HINCKLEY RAIL FREIGHT TERMINAL

Summary: Transport and Access

CPRE Leicestershire

Oct 2023

Written Statement of Oral Case ISH6 [Appendix C – Plan for A47 link road footway/cycleway design]

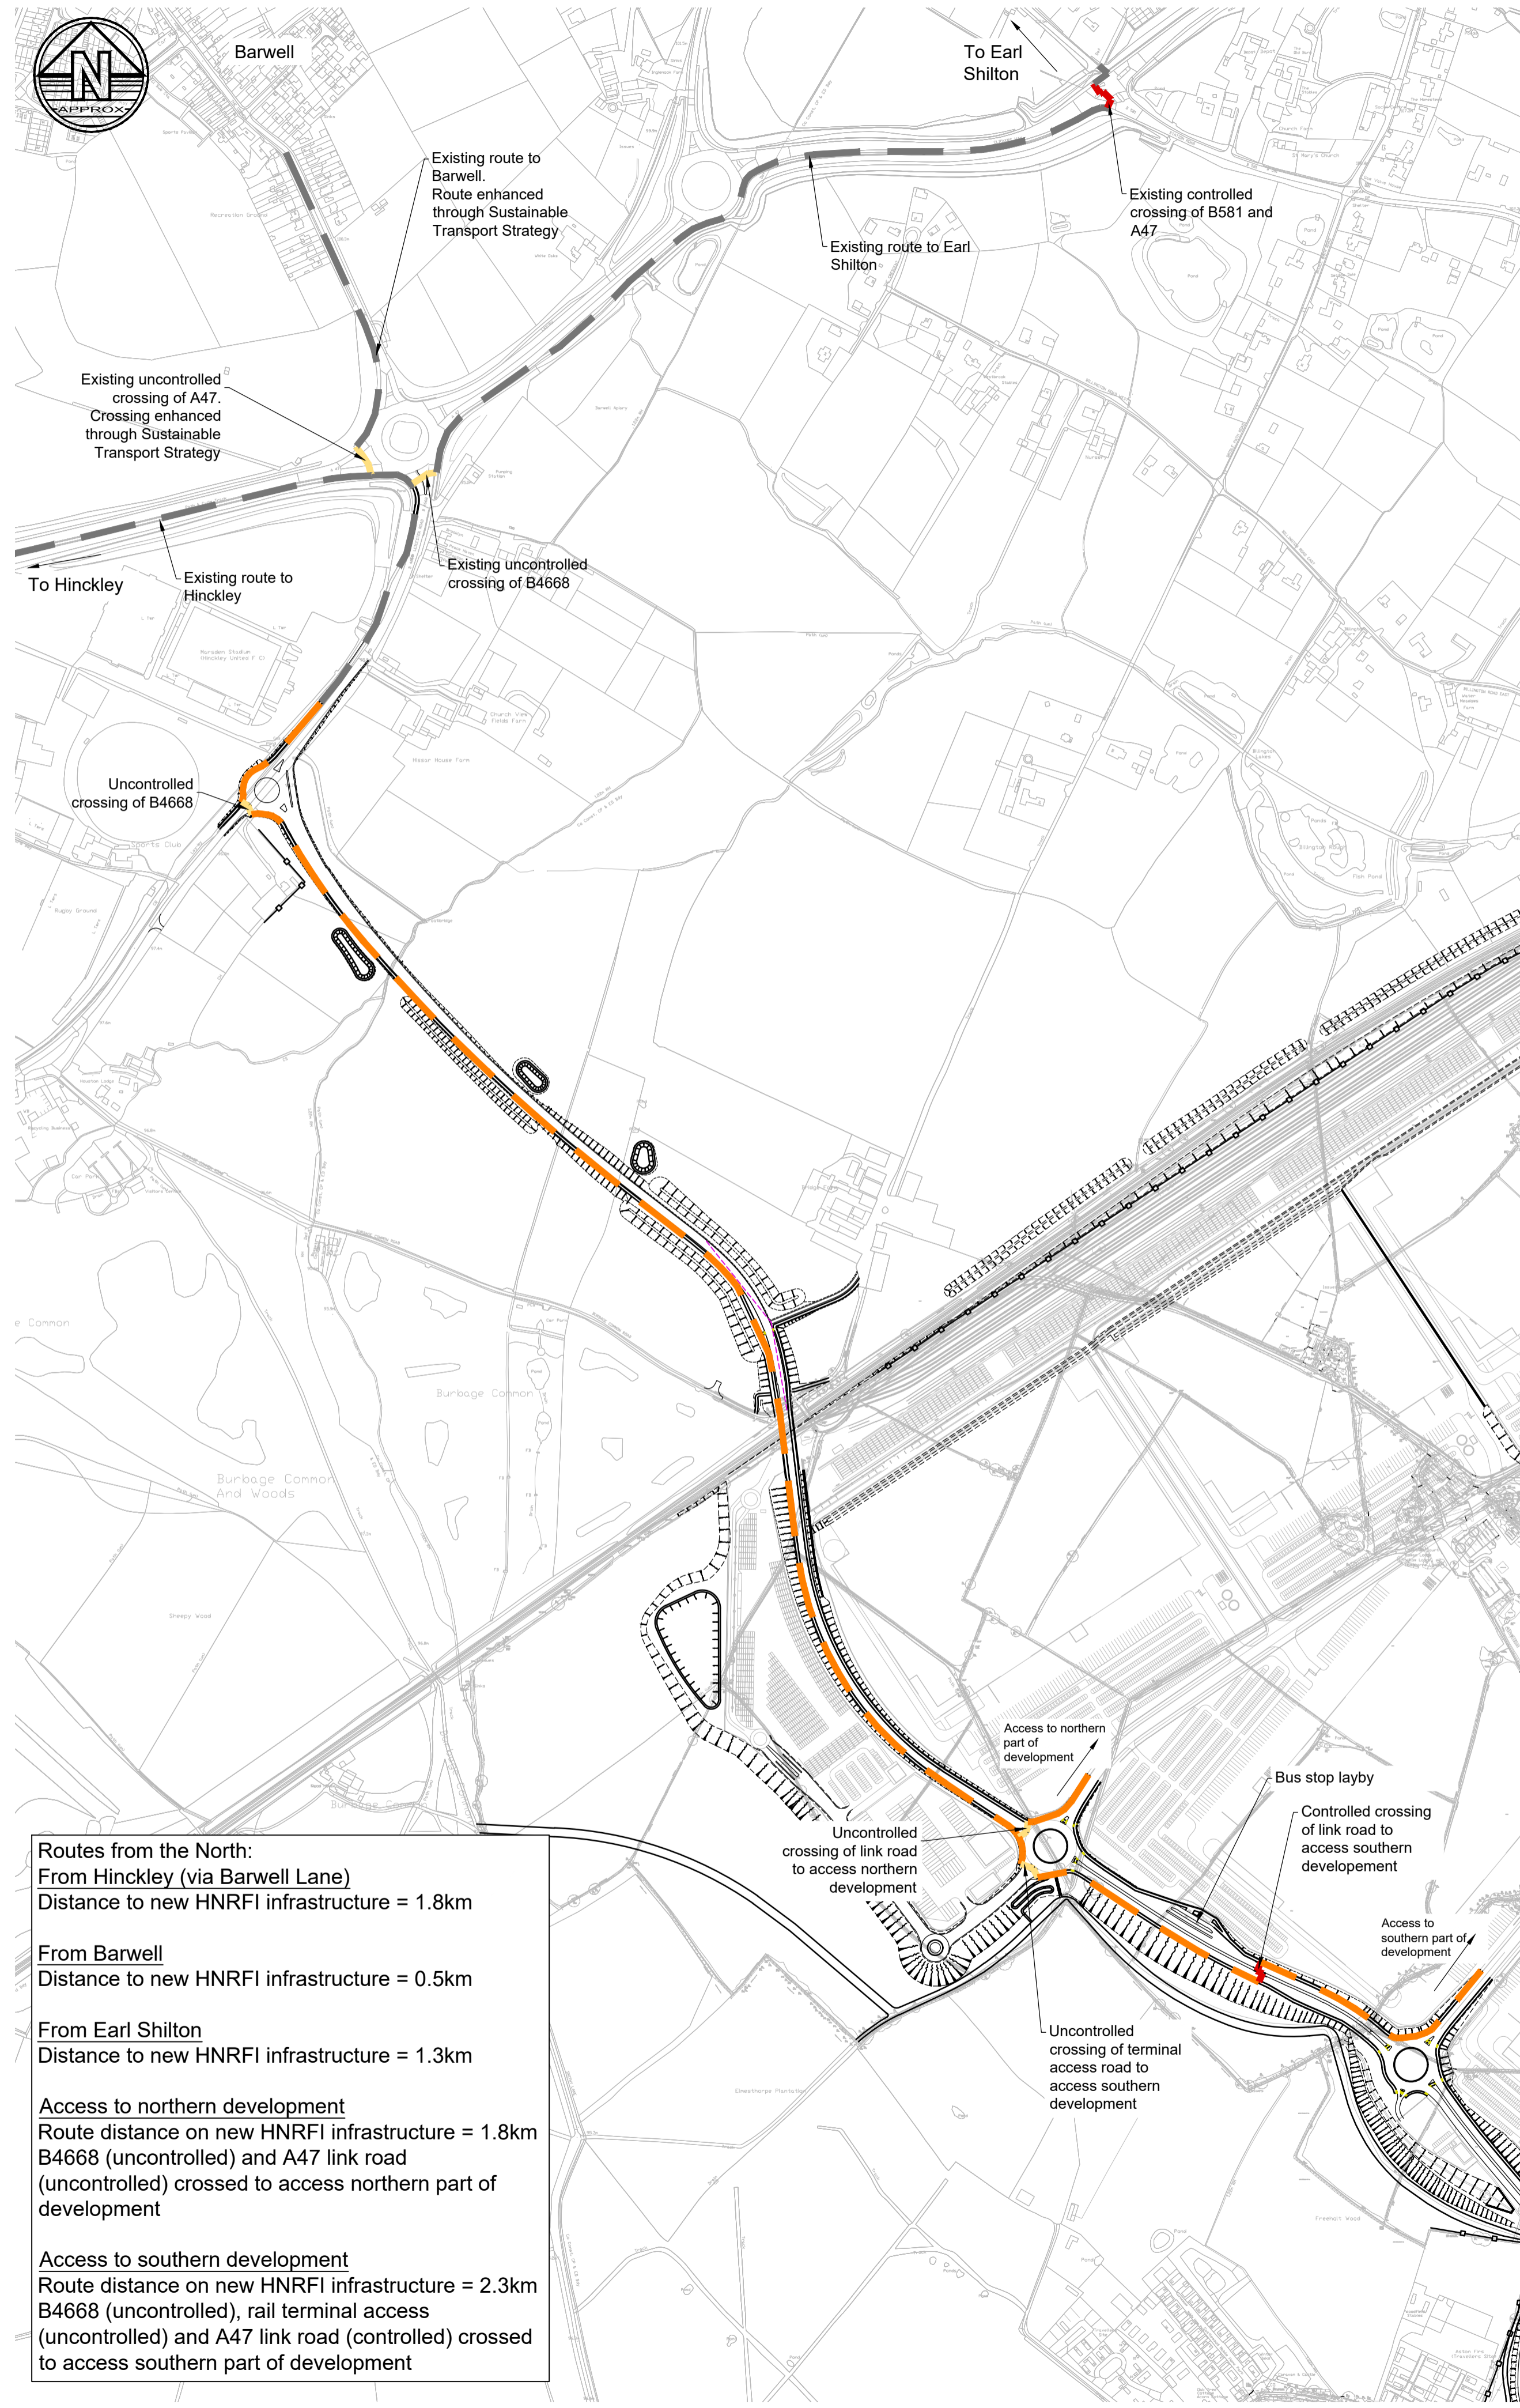
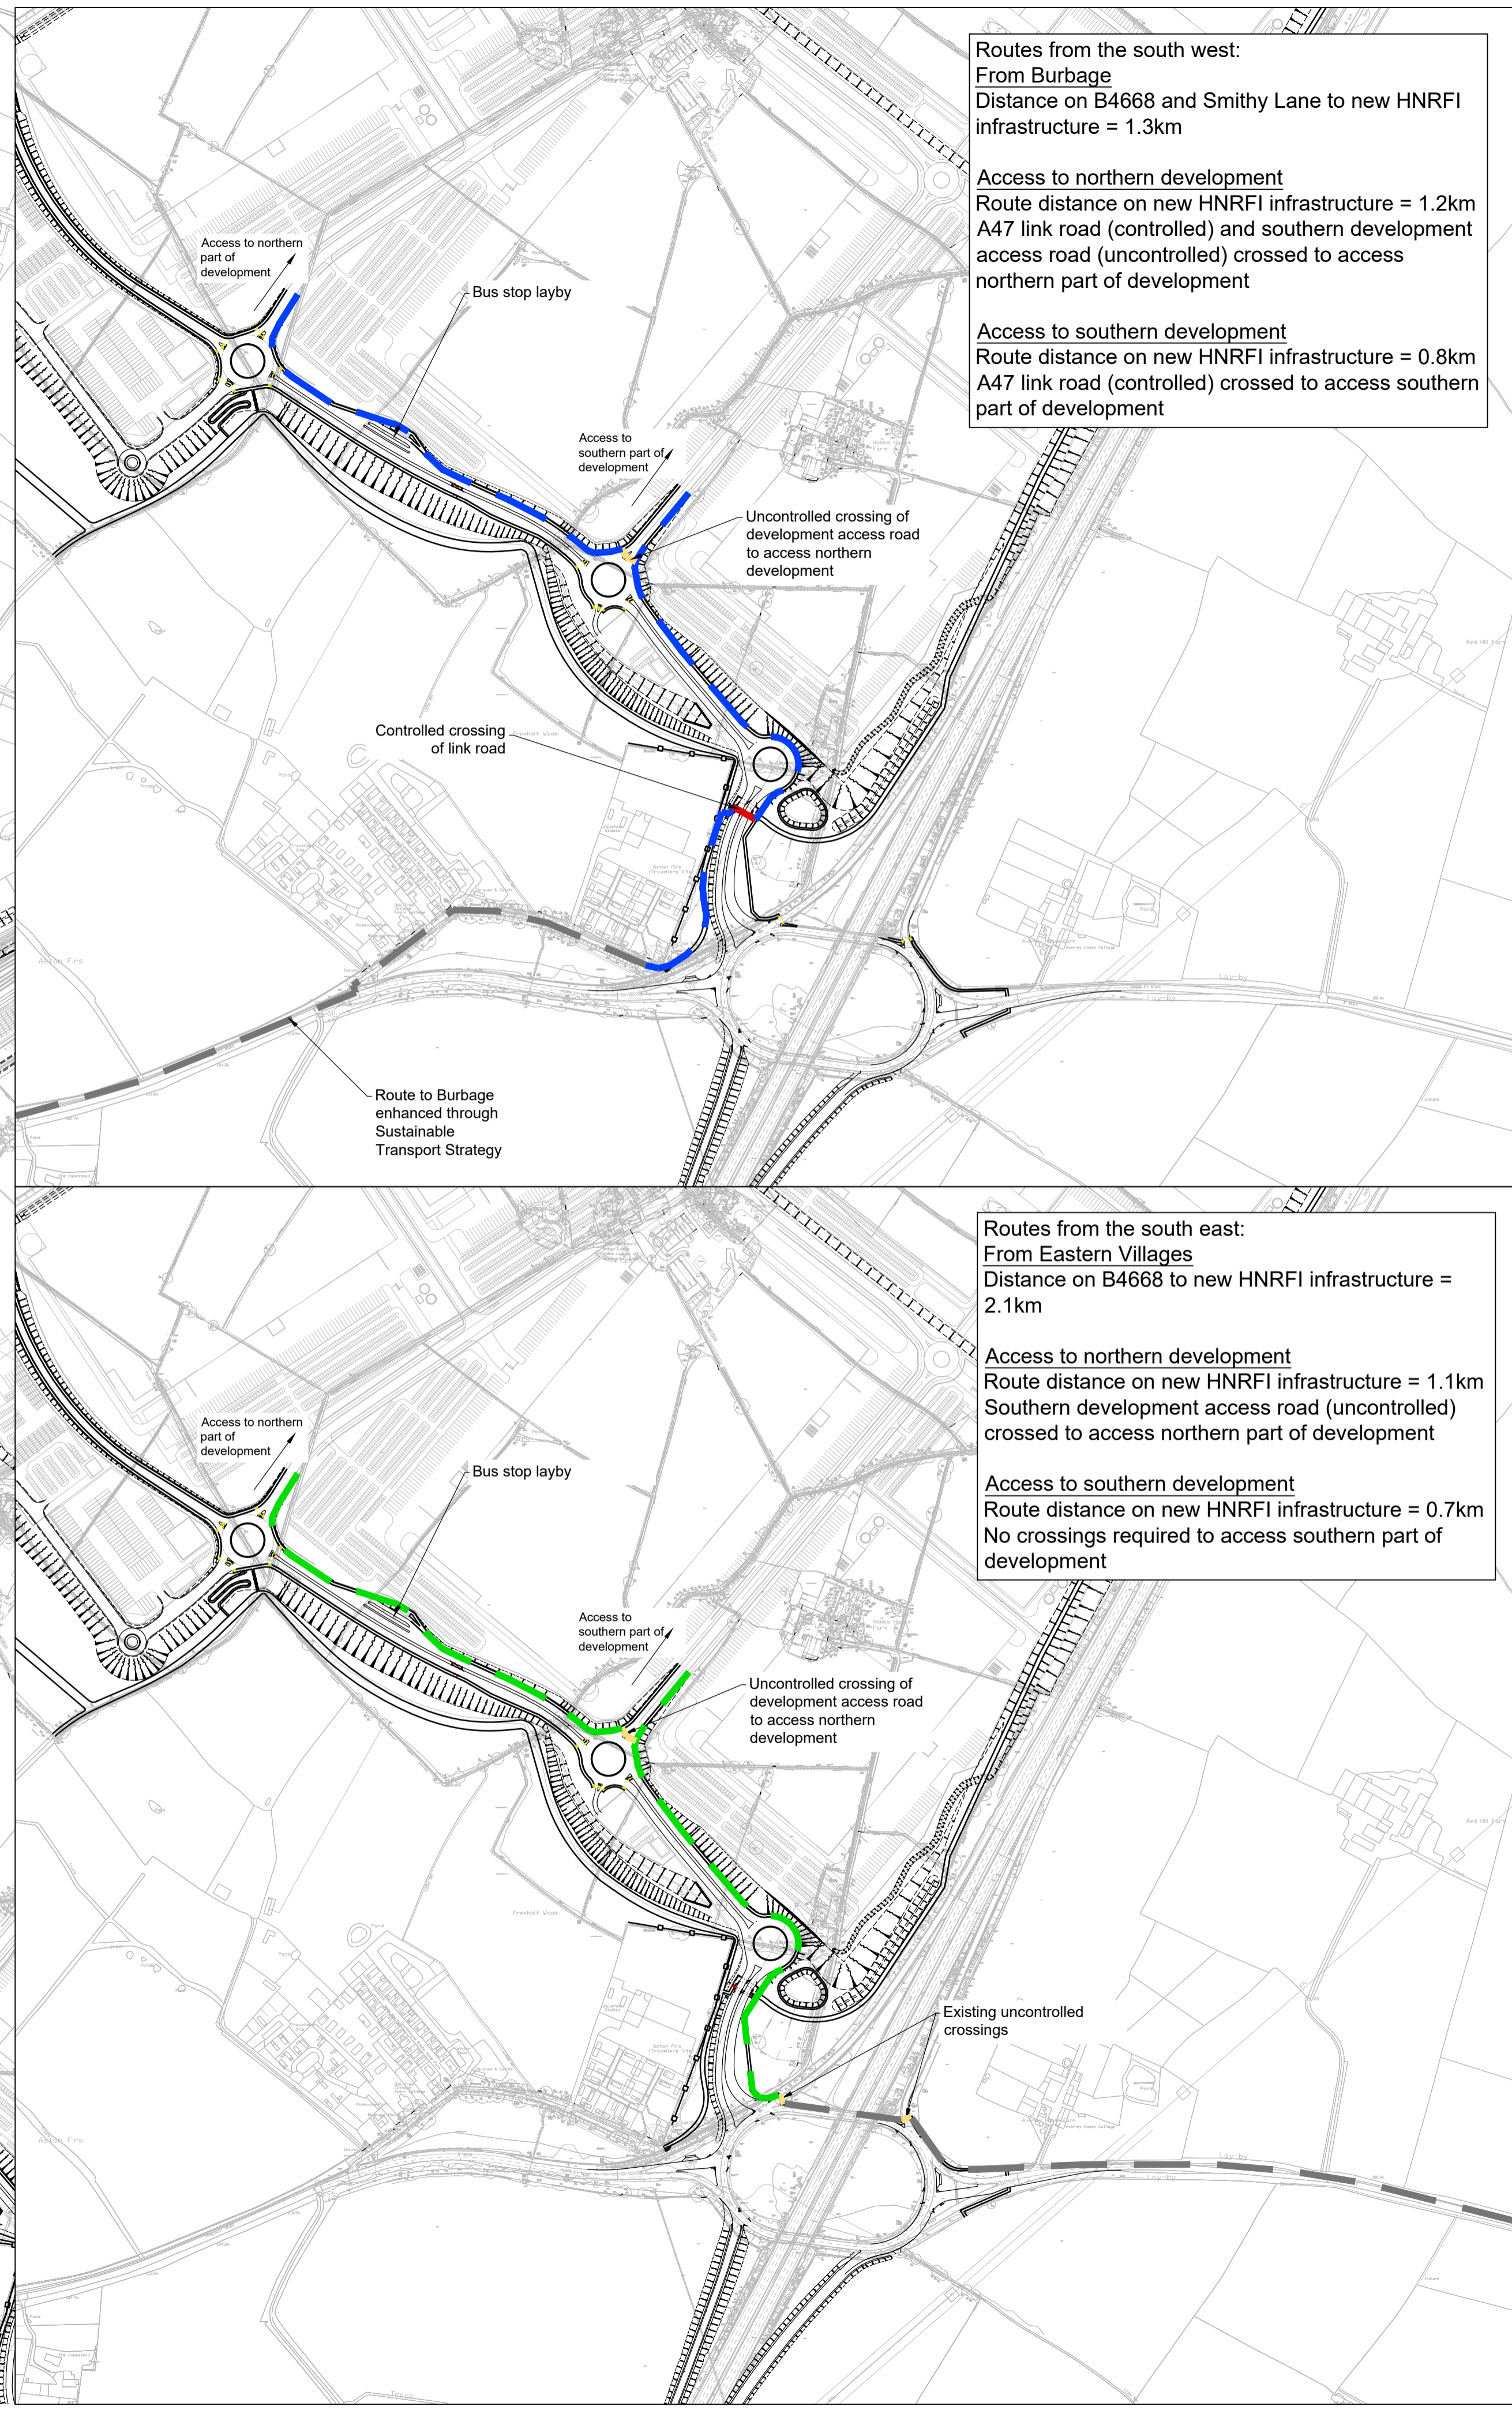
8.2.1 The site would be poorly situated for pedestrians. The entrance, via a newly constructed link-road, would not provide an attractive environment for pedestrians. Distances to the site would also be prohibitive.

8.2.3 The Assessment paints a glossy picture of potential improvements to the PROW network which is curtailed drastically between Hinckley and the motorway, as well as losing the opportunity to walk on the quiet Burbage Road. Pedestrians are forced onto the newly-constructed link road, then through the Industrial Park, or on a circuitous bridleway around the proposals. None would enjoy the attractiveness of the current routes through open countryside.
